Application No: K/2/22/HH
Site Address: 43 Golden Avenue East Preston BN16 1QX
Description of works: 2 storey front and rear extensions and alterations.

OWQC44624

Council has no objection providing the case officer is satisfied that:

Proposed Second Floor Plan

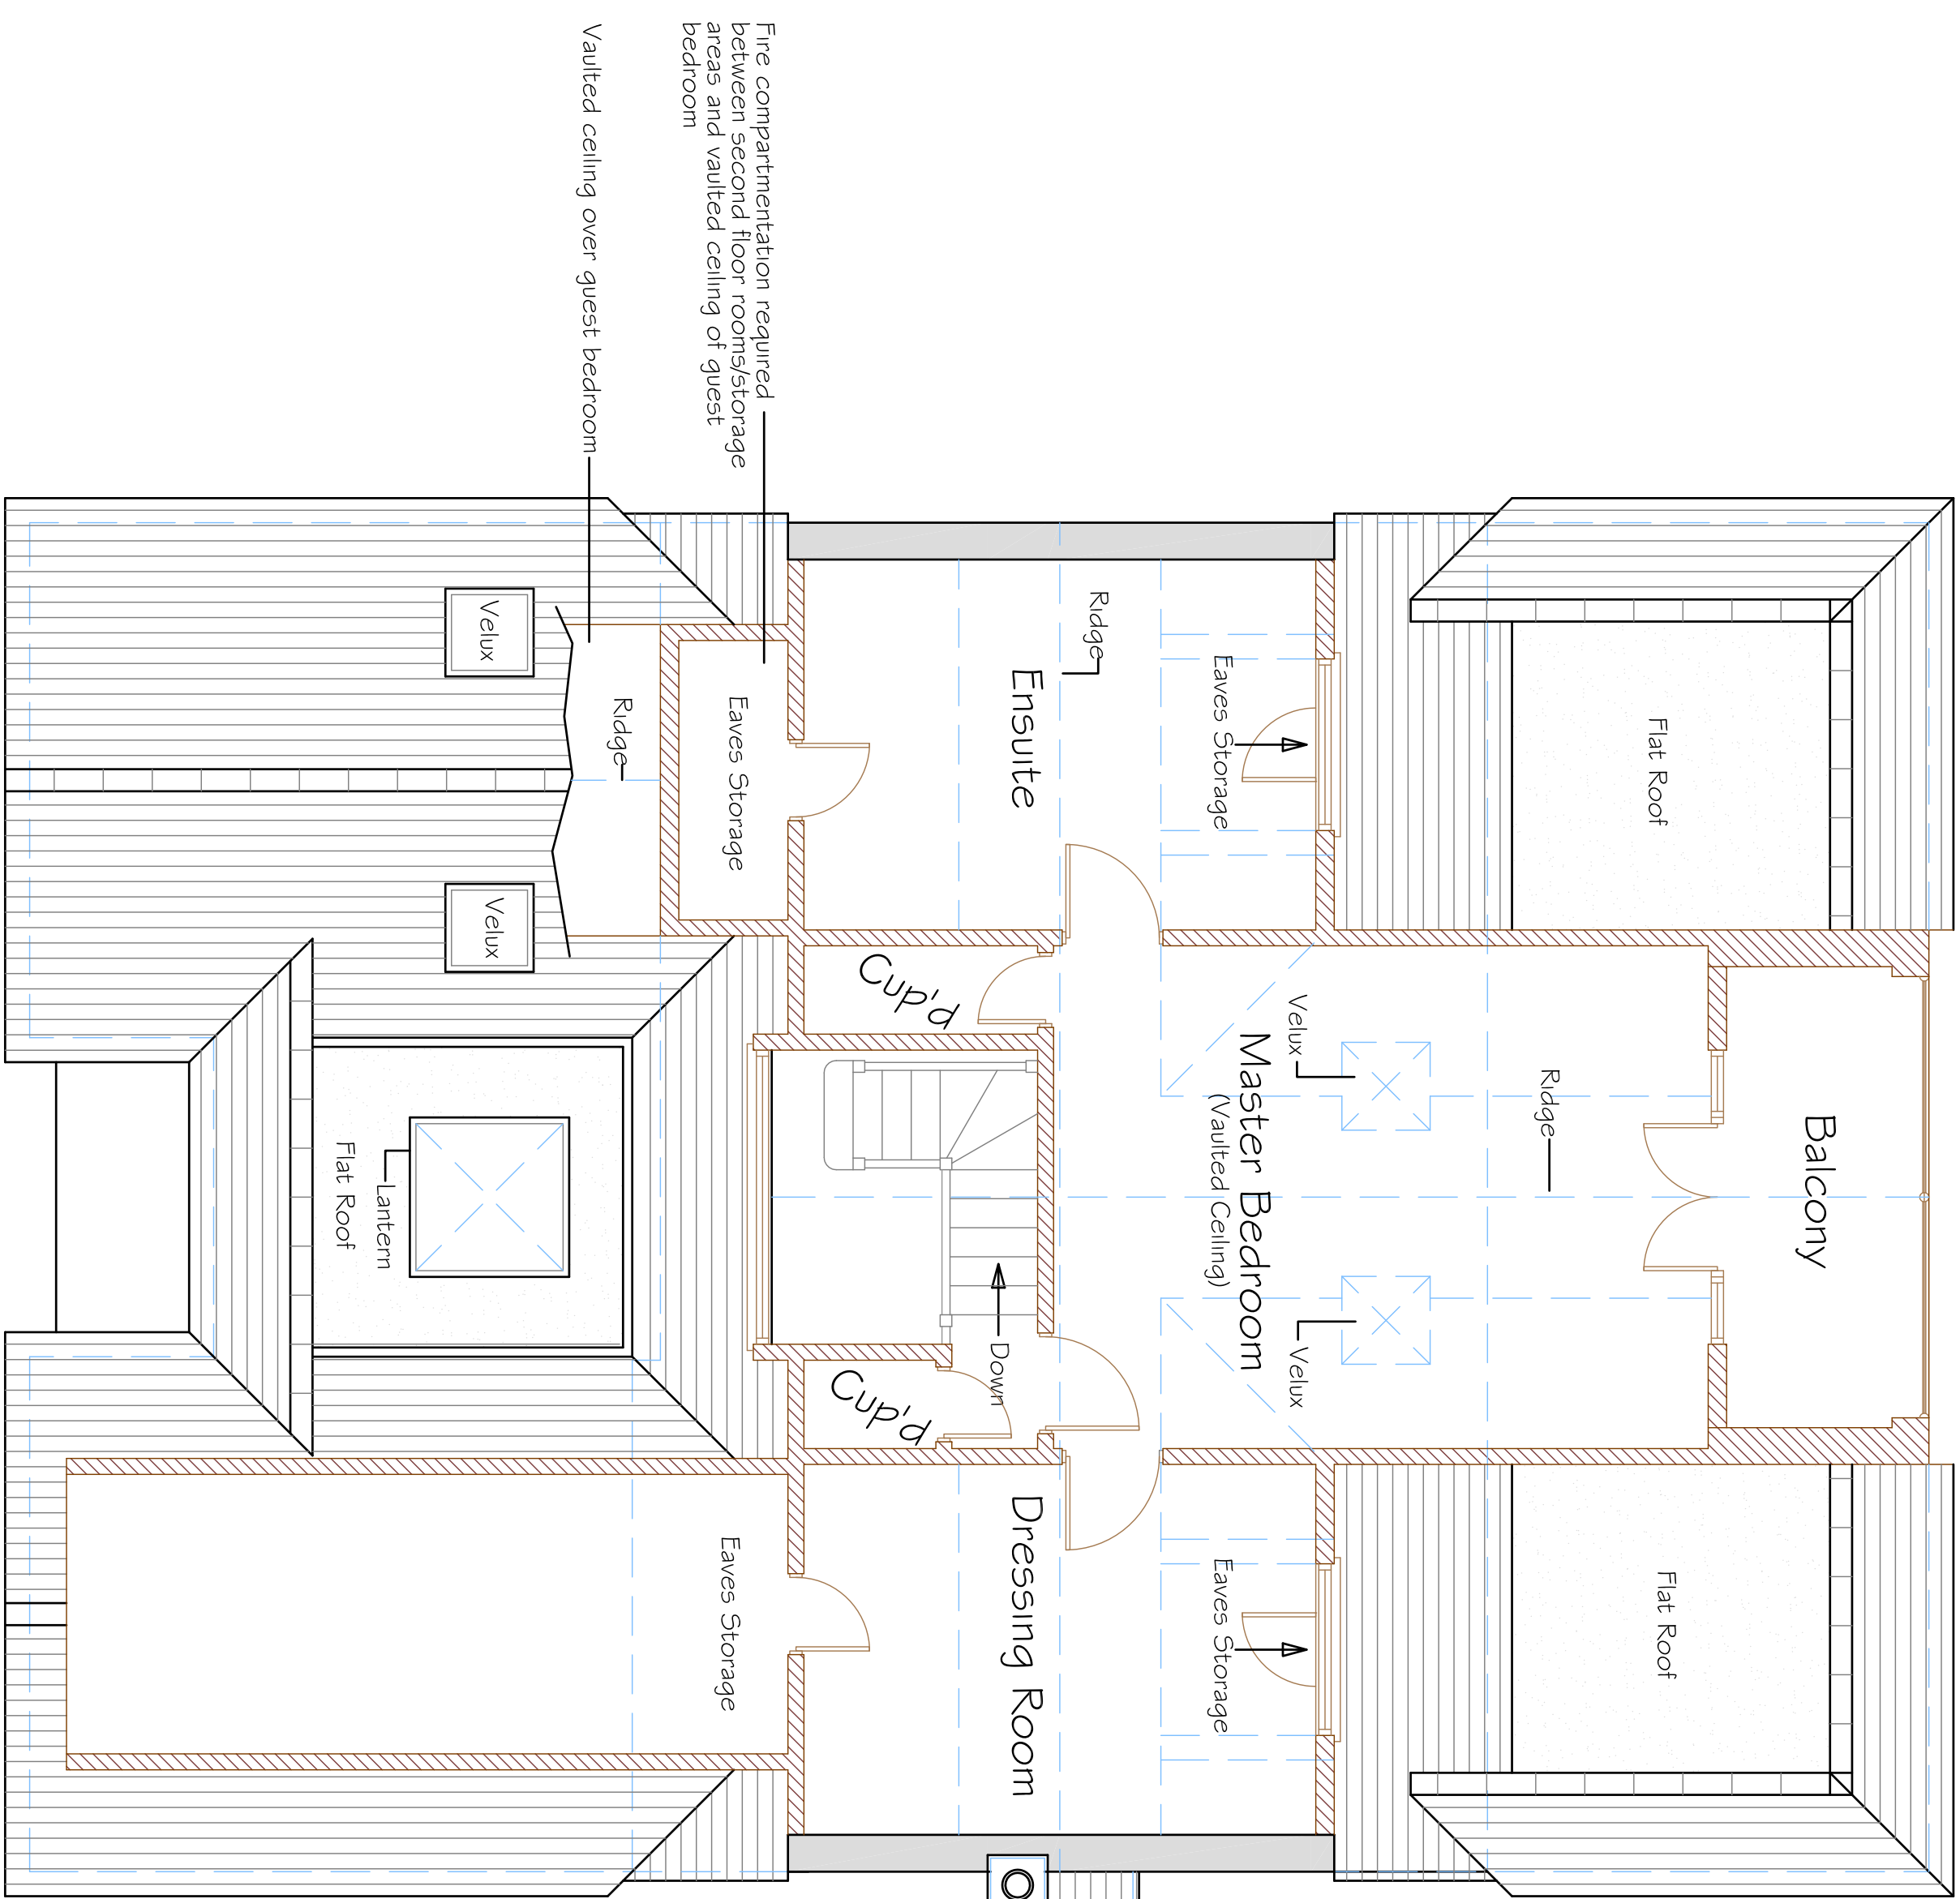
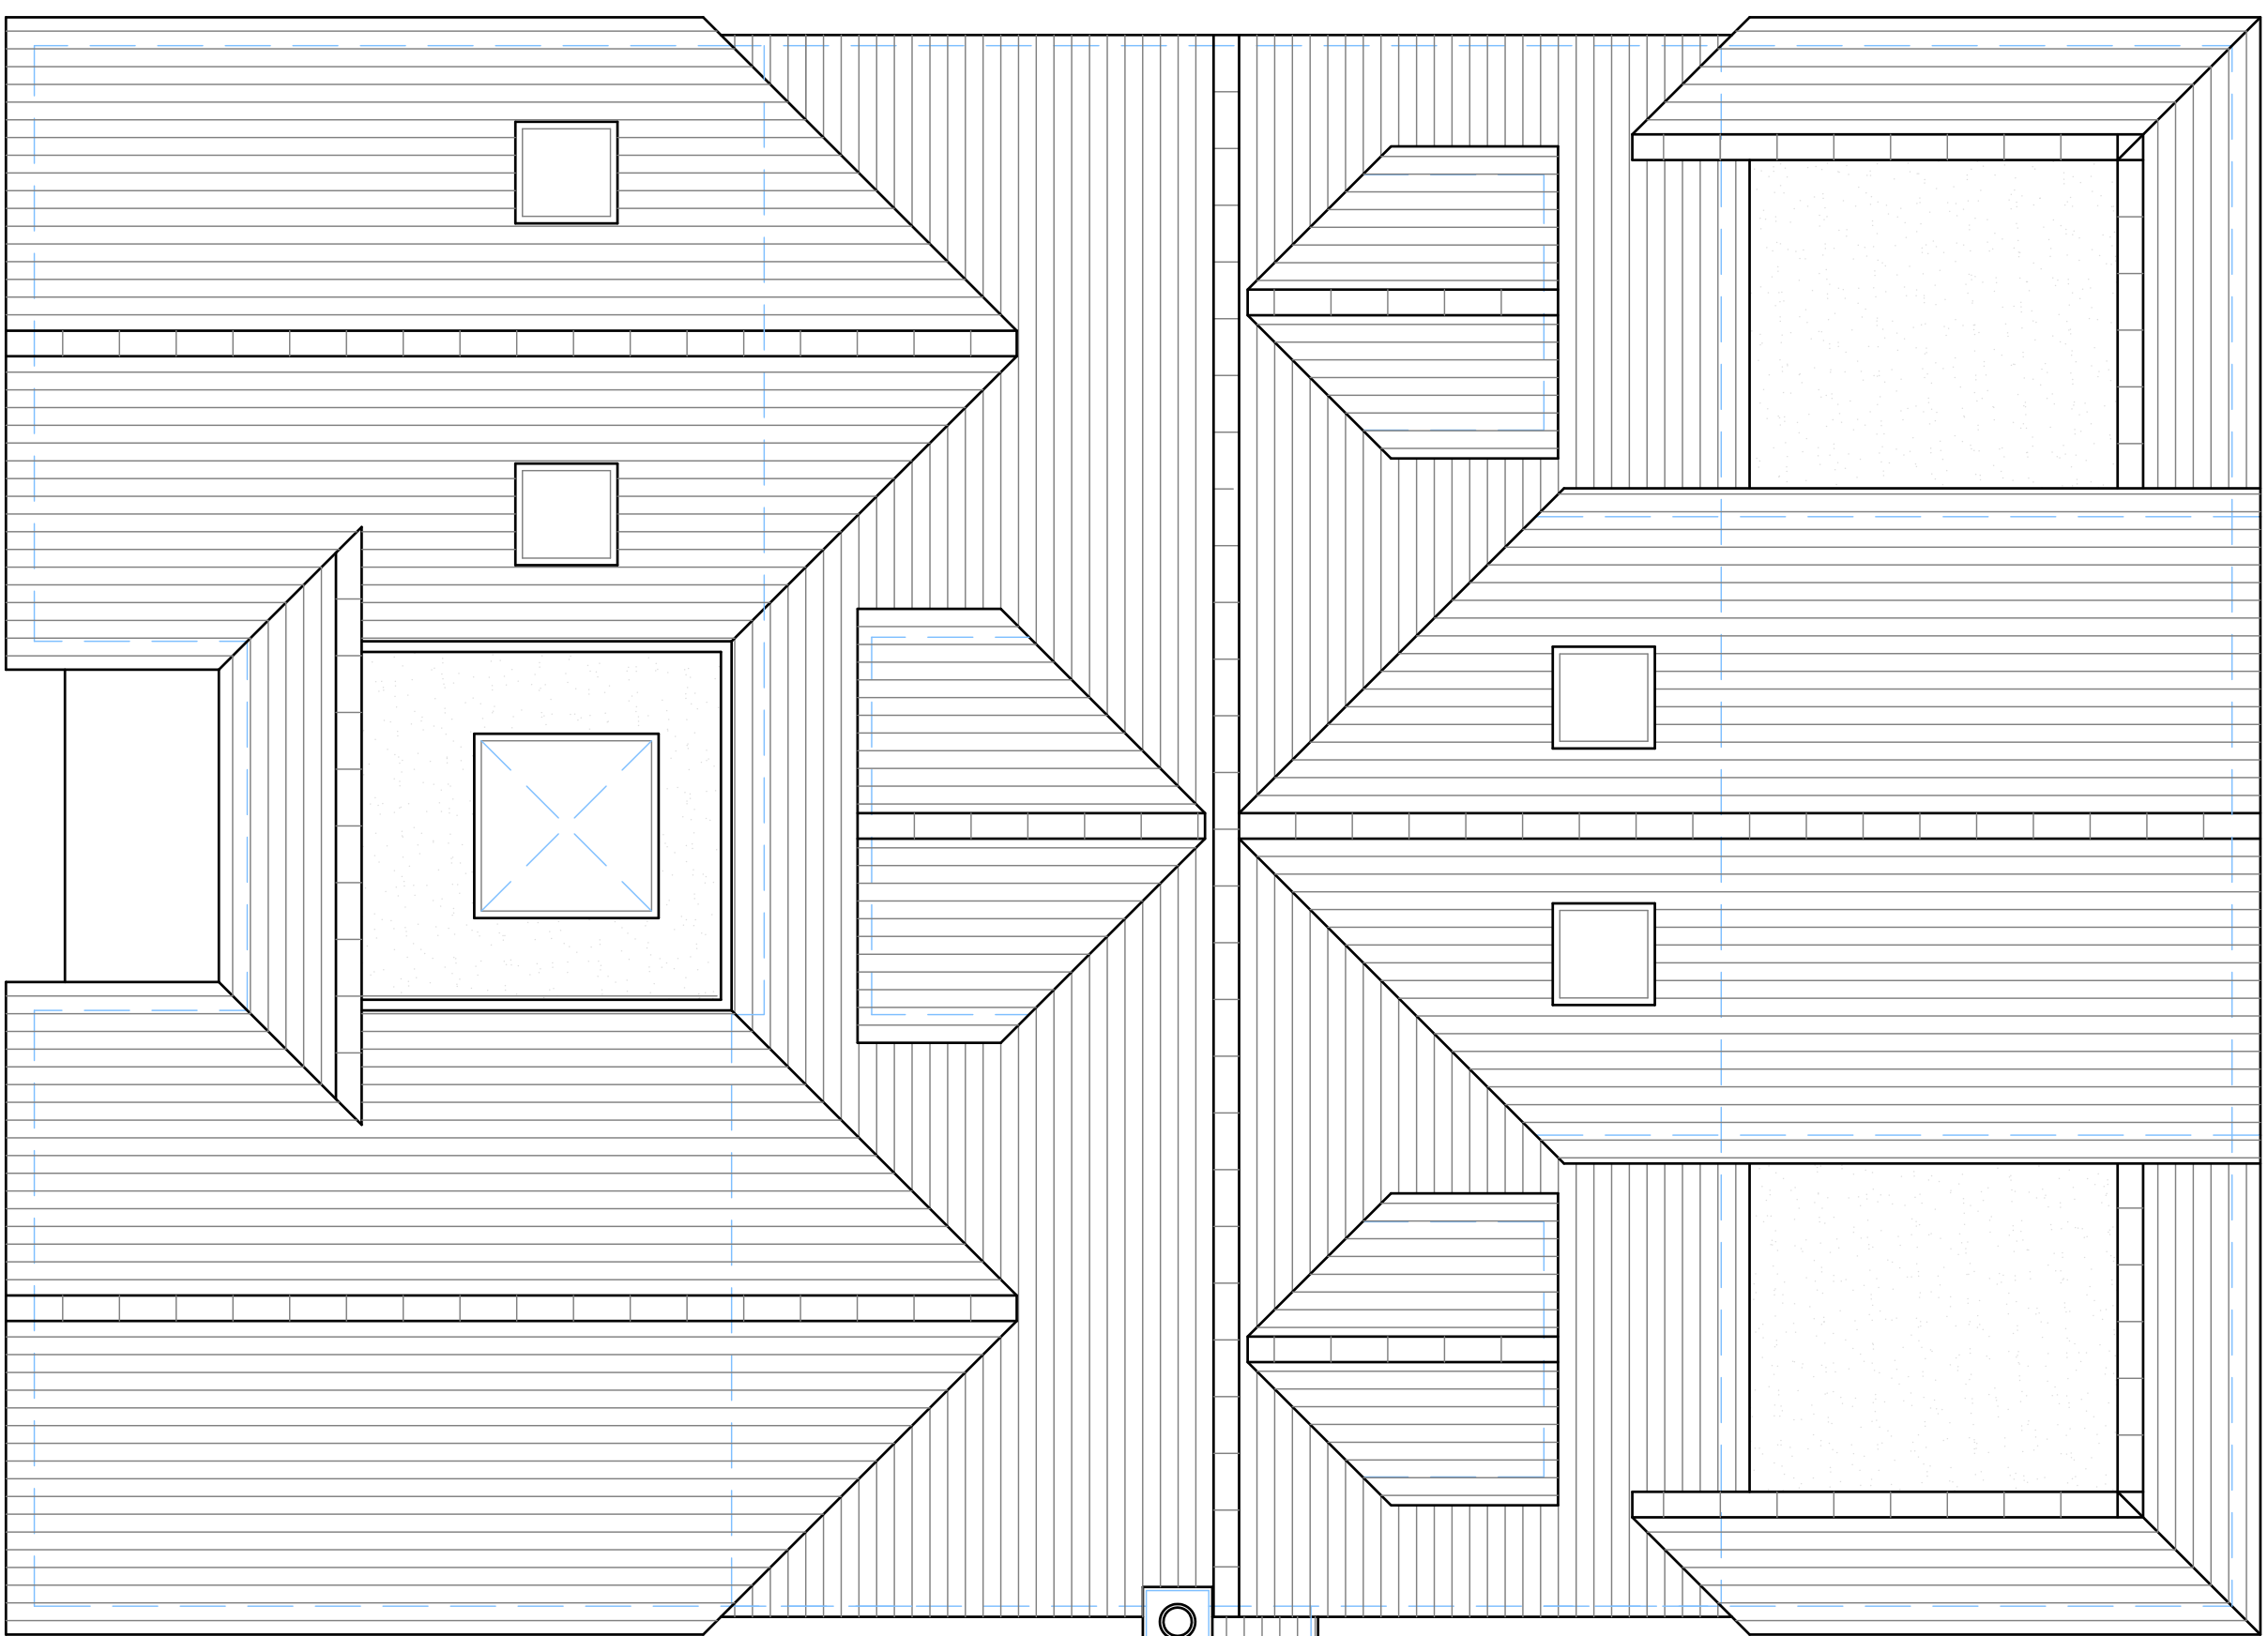
- there is appropriate on site parking for a 6 bedroom property
- windows on the side elevations have appropriate conditions as required to protect the privacy of neighbouring properties
- the new dormer windows and the new balcony at the rear on the second floor have appropriate conditions if required, to protect the privacy of neighbouring properties
